SSD 6011 - Mixed use residential development within the South West Plot

Submission by:

Patricia Cadell

21 July 2013

Winter Solstice 9am

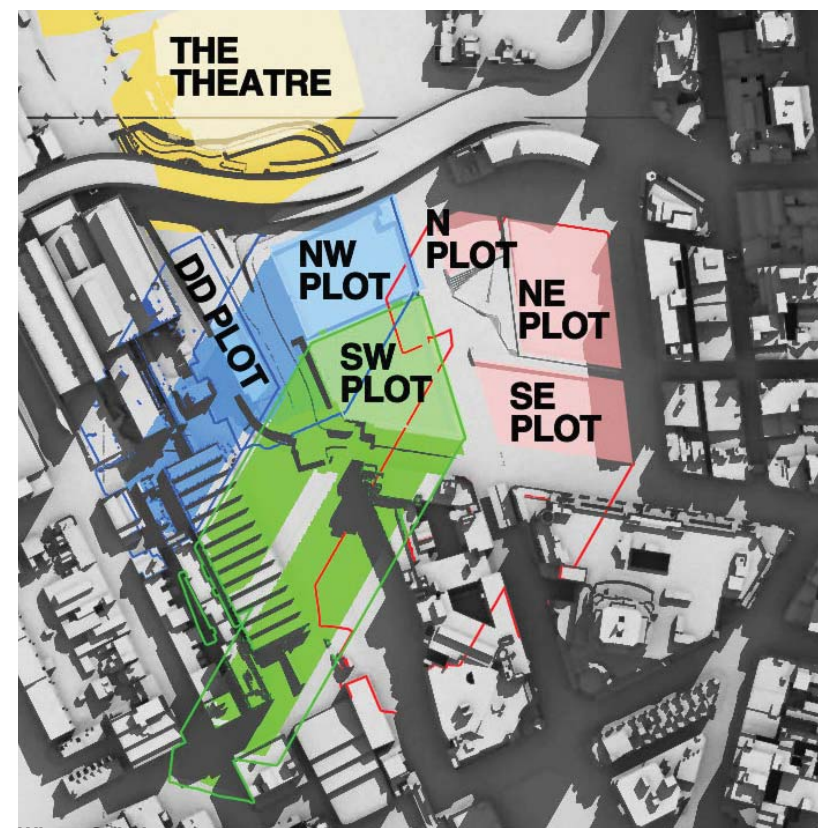
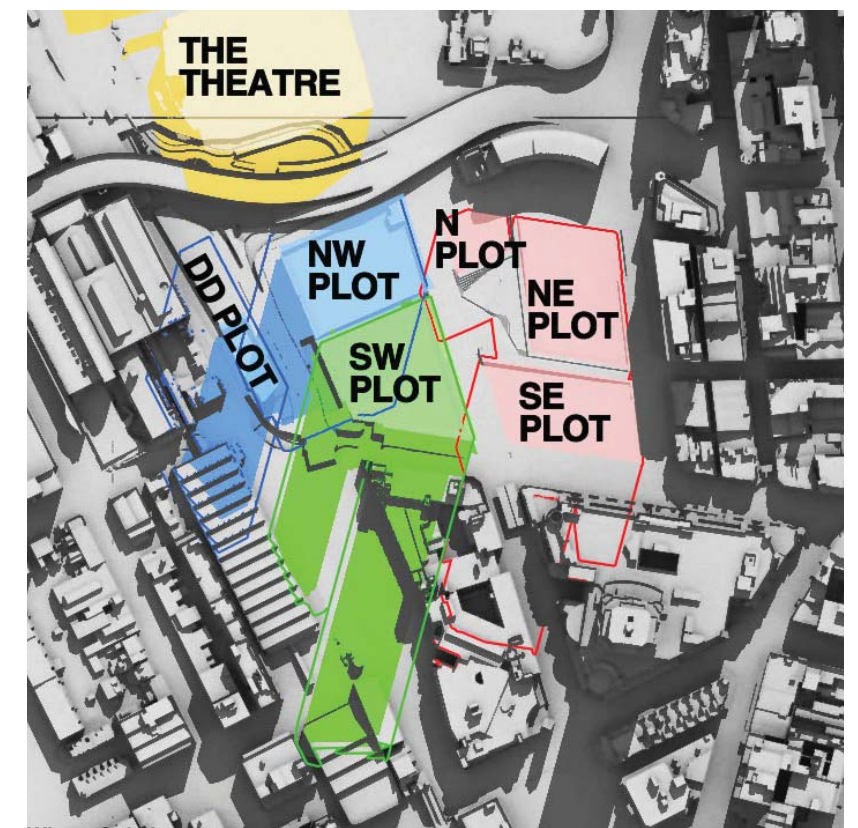
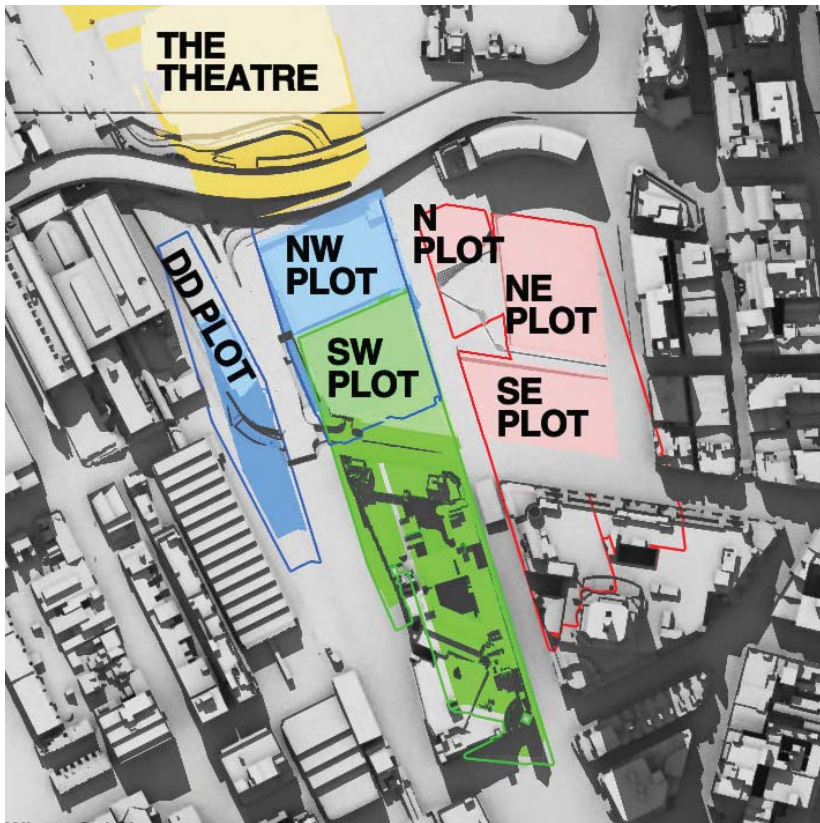
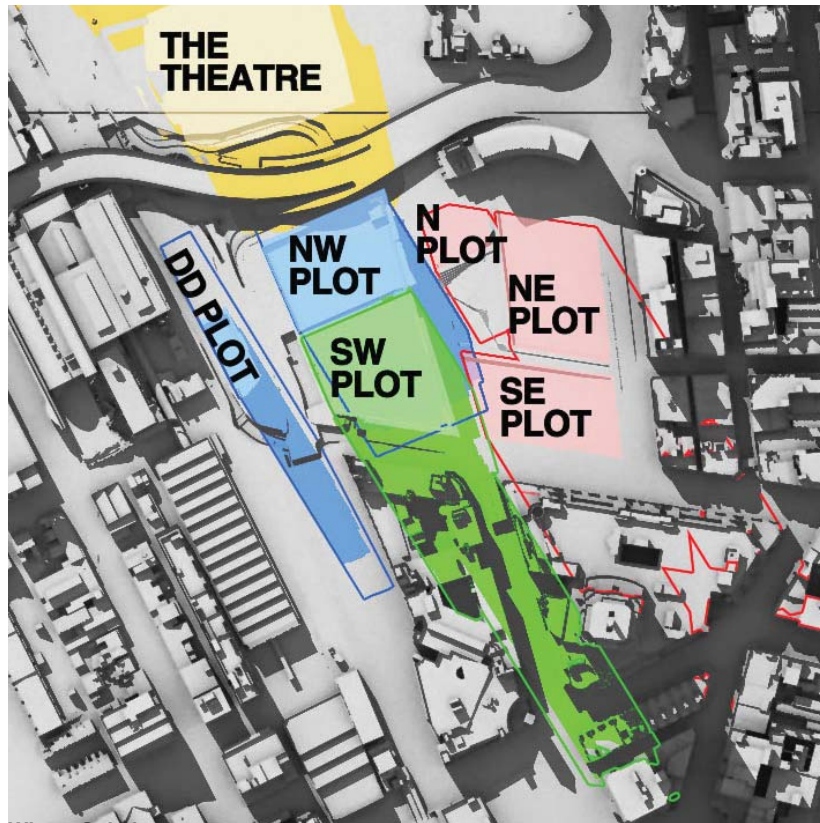
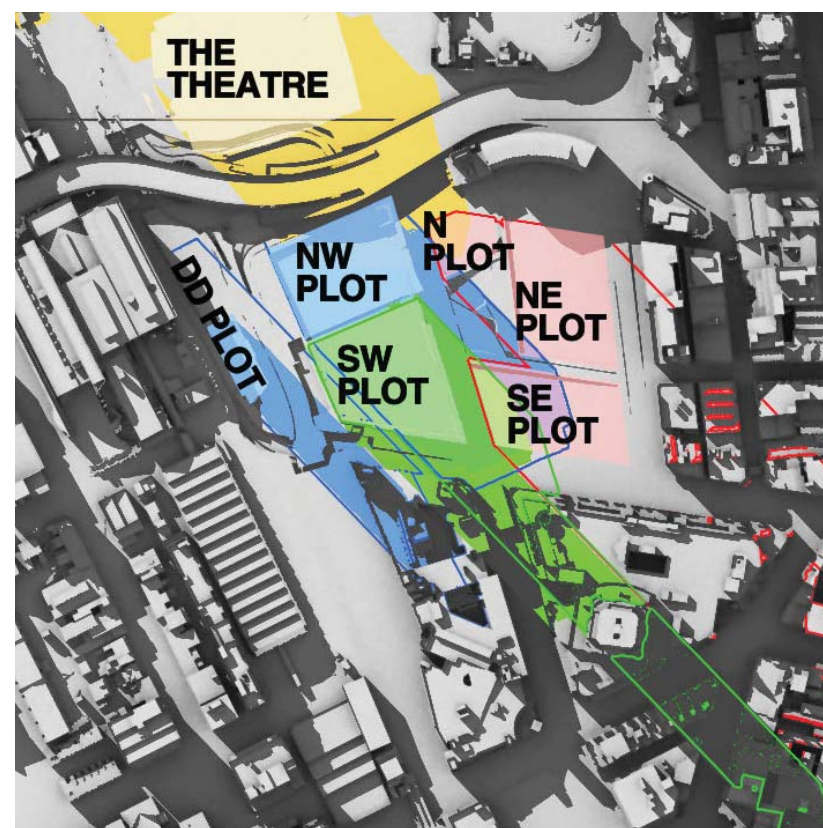
At 9am, 10am and 11am the west façade is totally in shadow due to other parts of The Peak building itself.

At 12pm there is still substantial existing shadowing on the west façade caused by the irregular shape of the west facade.

At 1pm the existing shadowing has been substantially removed, but not totally removed.

It can be concluded that some single aspect apartments on the west façade and some south-west dual aspect corner apartments currently receive less than 2 hours direct sunlight to habitable rooms and 50% of the private open space between 9am and 3pm on 21 June.

By 2pm the existing shadowing has been totally removed, but that is too late to achieve two hours of direct sunlight before 3pm.

At 9am, 10am and 11am the west façade is totally in shadow due to other parts of The Peak building itself.

At 12pm there is still substantial existing shadowing on the west façade caused by the irregular shape of the west facade.

At 1pm the existing shadowing has been substantially, although not entirely, removed. However, overshadowing of lower levels of the west façade by the concept proposal parameter plan shadows for the N,NE and SE plots has already started.

By 2pm the existing shadowing has been totally removed. However, overshadowing of the west façade by the SSDA4 and SSDA5 buildings has appeared and risen further up the west façade than the concept proposal parameter plan shadows for the N,NE and SE plots, which is still present.

At 3pm, the proponent states correctly that 45-45% of the western façade is overshadowed by the SSDA4 and SSDA5 buildings.

It can be concluded that, as a result of combination of the proposed development with existing shadowing of the west façade, some single aspect apartments on the west façade and the south-west dual aspect corner apartments which currently receive less than 2 hours direct sunlight to habitable rooms and 50% of the private open space between 9am and 3pm on 21 June will suffer additional overshadowing. It is beyond our skills to count the number of such apartments. We note that the proponent has made no attempt to do so.
